Powur Solar Comment Response Letter
Permit KARLA YESENIA CLAVEL
AHJ - HARNETT COUNTY

Date: April 12, 2024

This letter serves as supplementary input to the corrections made for the comments issued the photovoltaic project located at 36 ATHENS CT, CAMERON, NC 28326, USA. The comments made were addressed as follows:

SHEET NUMBER
 PV-2

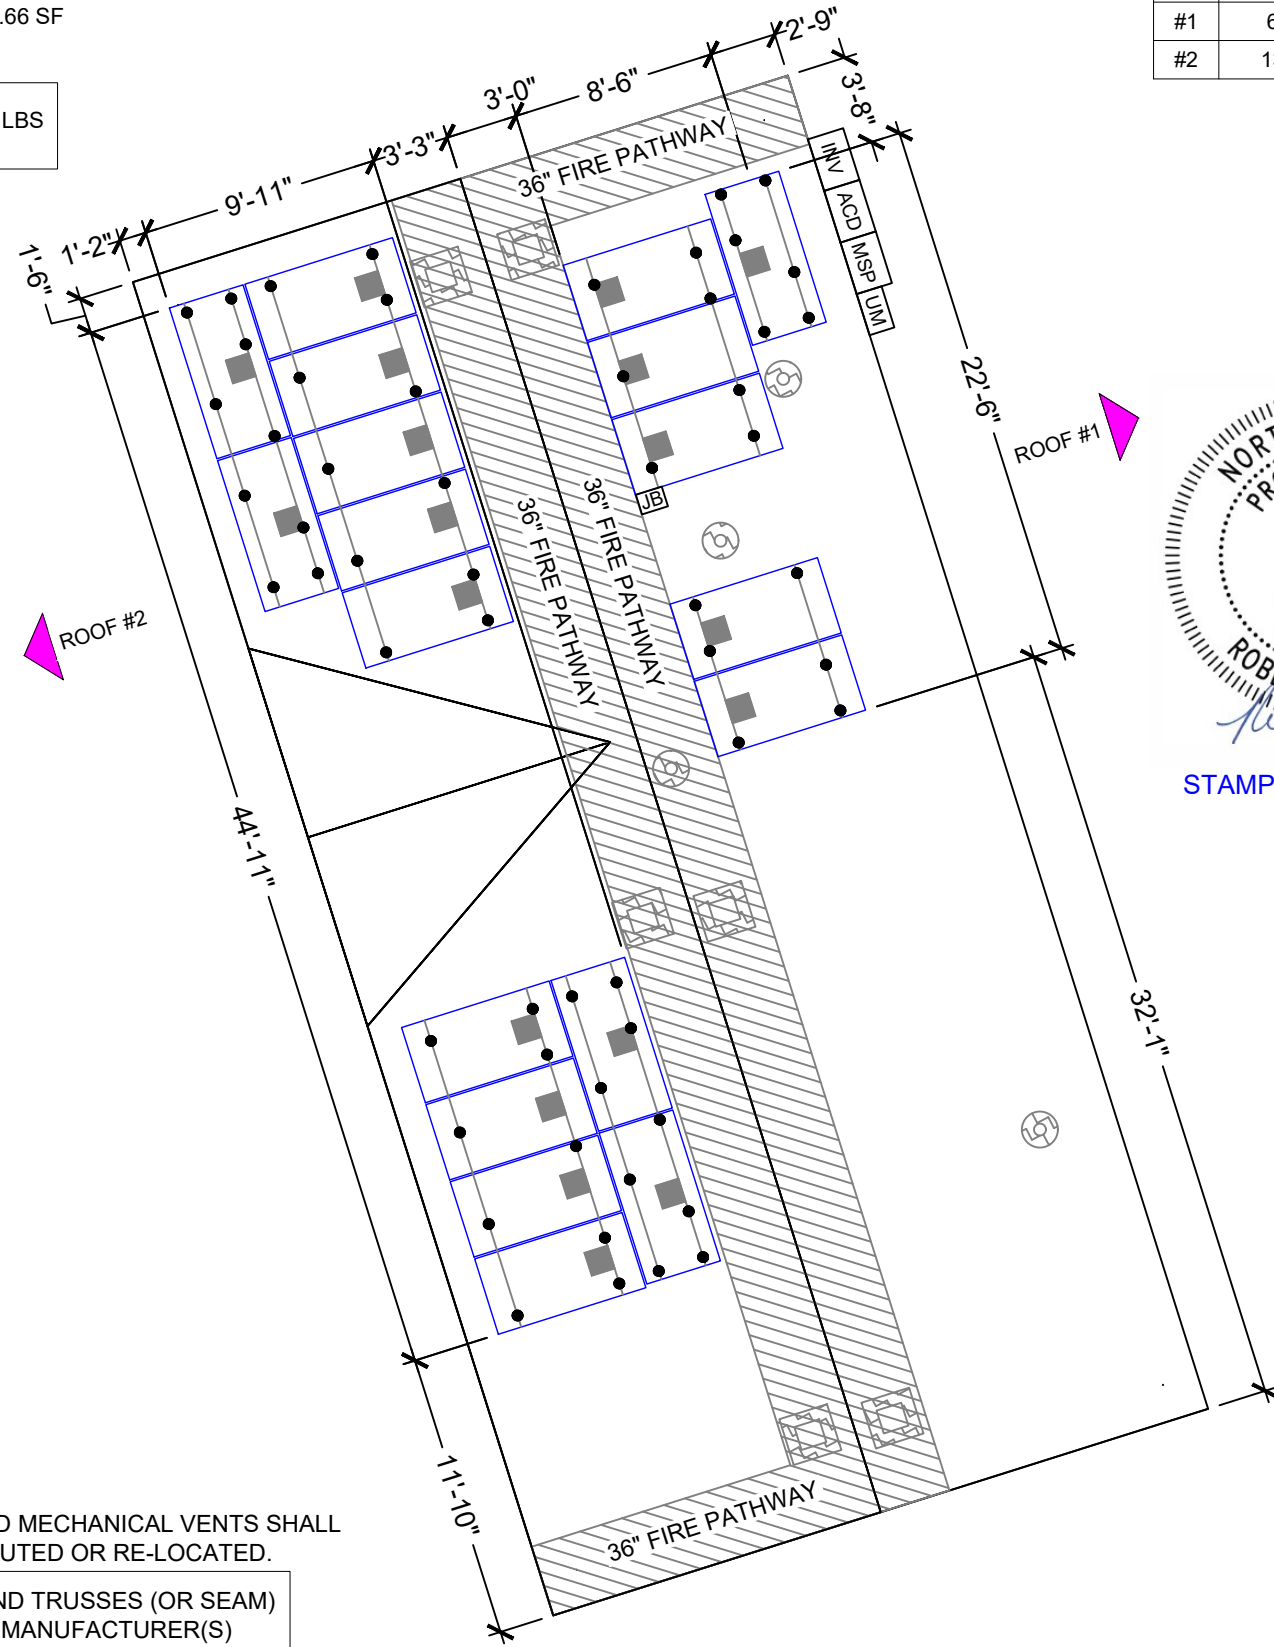
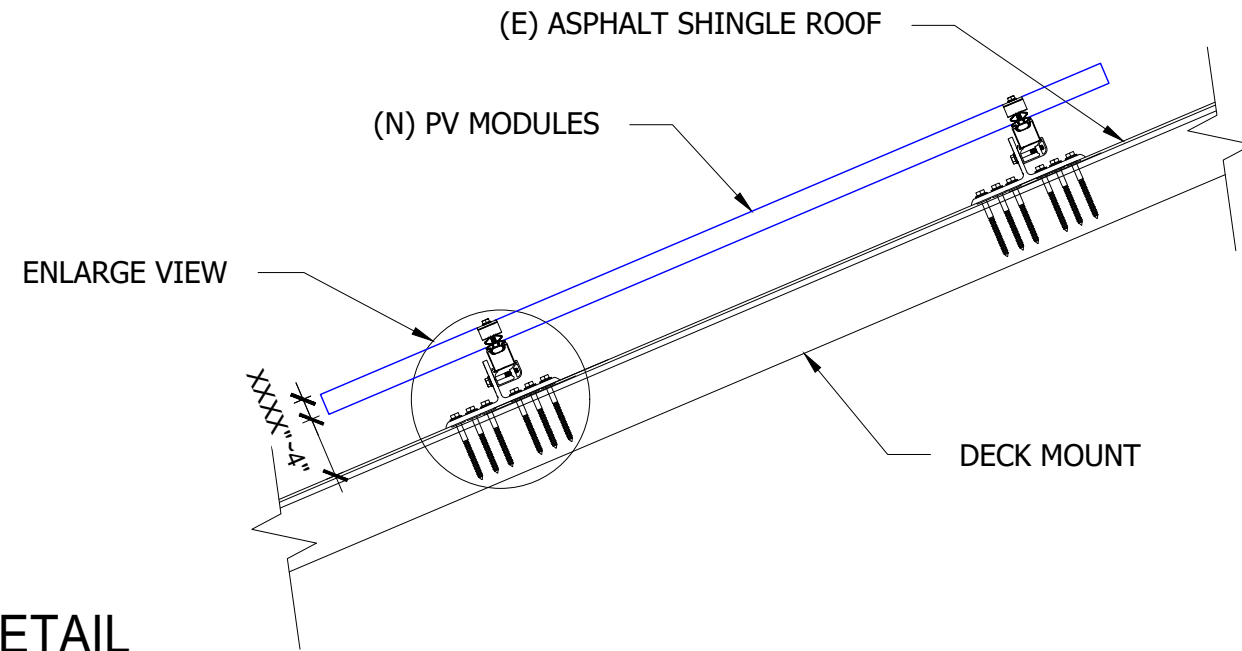
Comment #1 (PV-2, 3, 10, 11 & 12): Change the attachment to Duos to Butyl

Response: We have changed the attachment Duos to Stronghold Butyl.
